**DELEGATED DECISION TO DETERMINE PLANNING APPLICATIONS TO
CARRY OUT DEVELOPMENT WITHOUT COMPLIANCE WITH PLANNING
CONDITIONS PREVIOUSLY ATTACHED**

Reference No:	2022/70/92365/W
Site Address:	former railway goods yard, adj, Fold Farm, Netherton Fold, Netherton, Huddersfield, HD4 7HB
Description:	Variation condition 2 (plans) on previous permission 2019/92361 for Erection of 19 dwellings
Recommending Officer:	Ellie Worth

Officer report

House Type A - 2633ft²
Proposed Floor Plans & Elevations

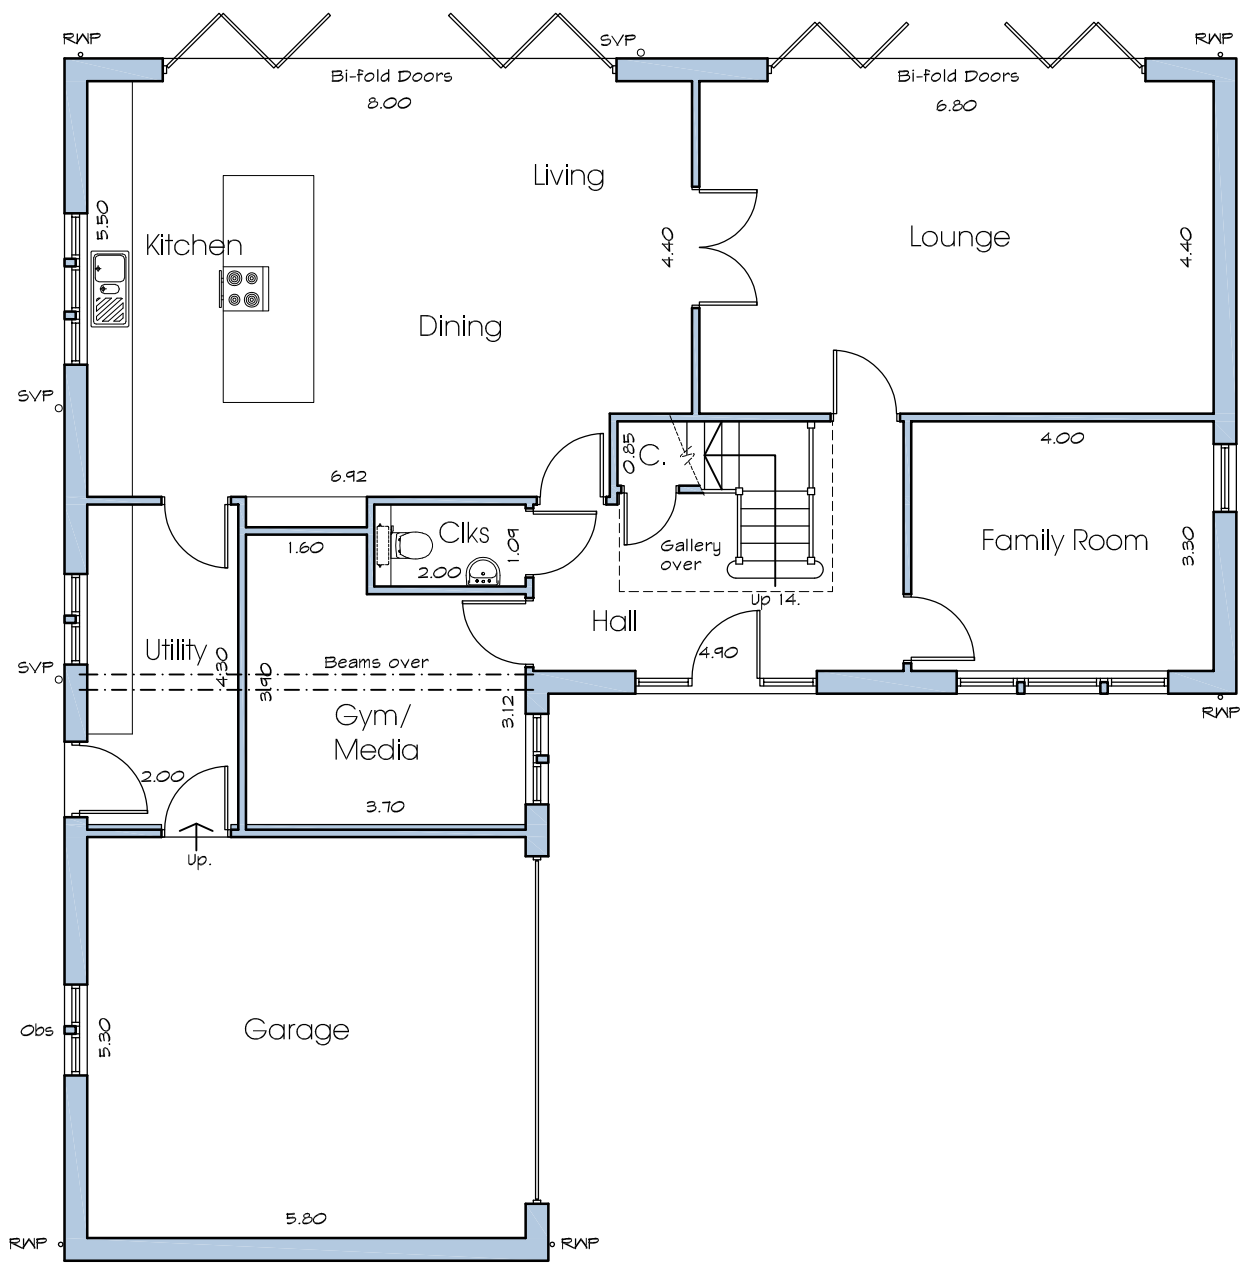
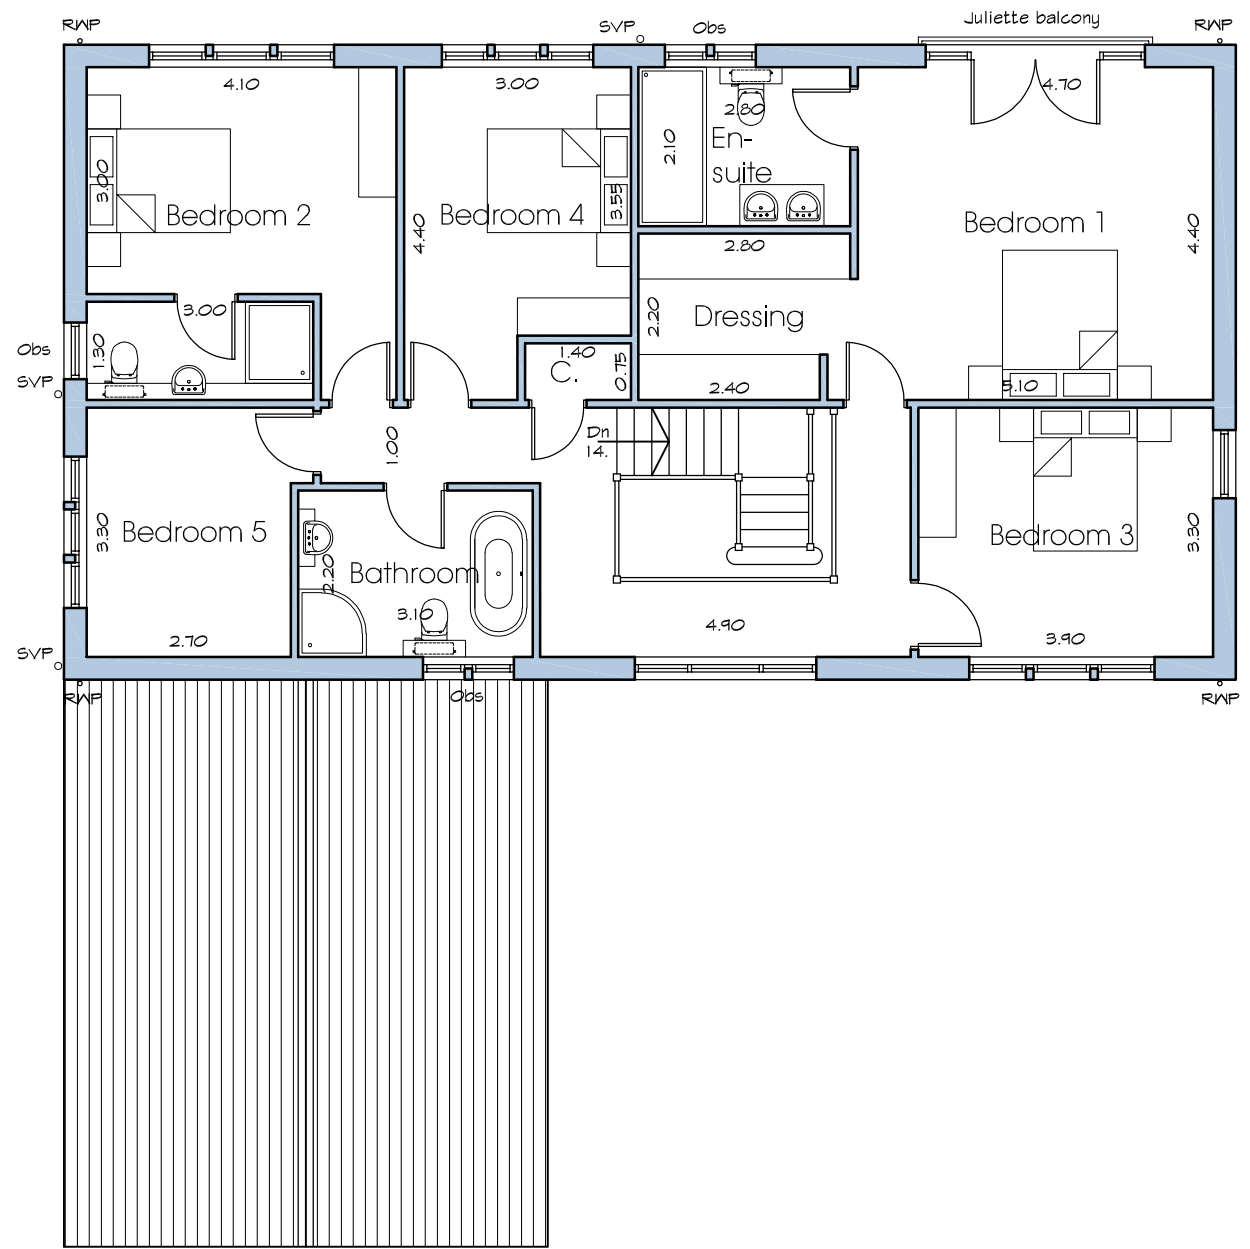
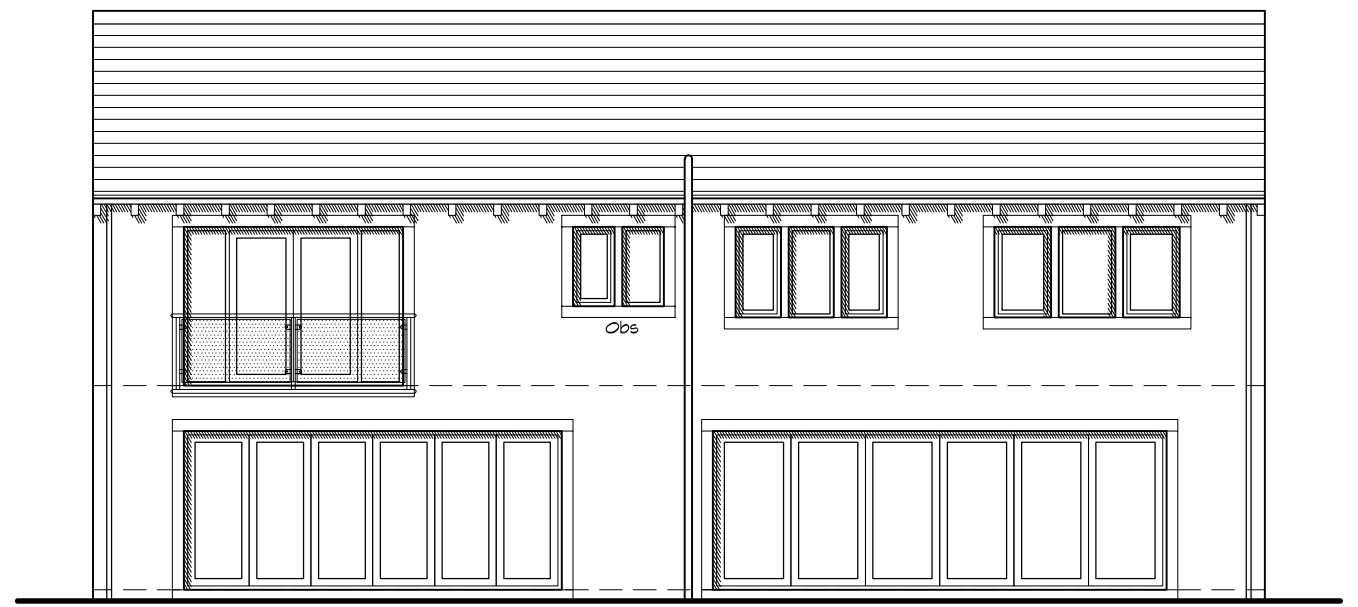
In this instance, the variation sought seeks to slightly amend the design finishes for plots 1 and 2 in order to allow the maintenance of a highway burr wall, designed by structural engineers. The changes to plot 1 include a variation in the entrance window arrangement and the installation of smaller, panelled doors to the bi-folds on the rear elevation. Plot 2 would include less glazing to the side elevation of the garden room, due to the installation of the burr wall.
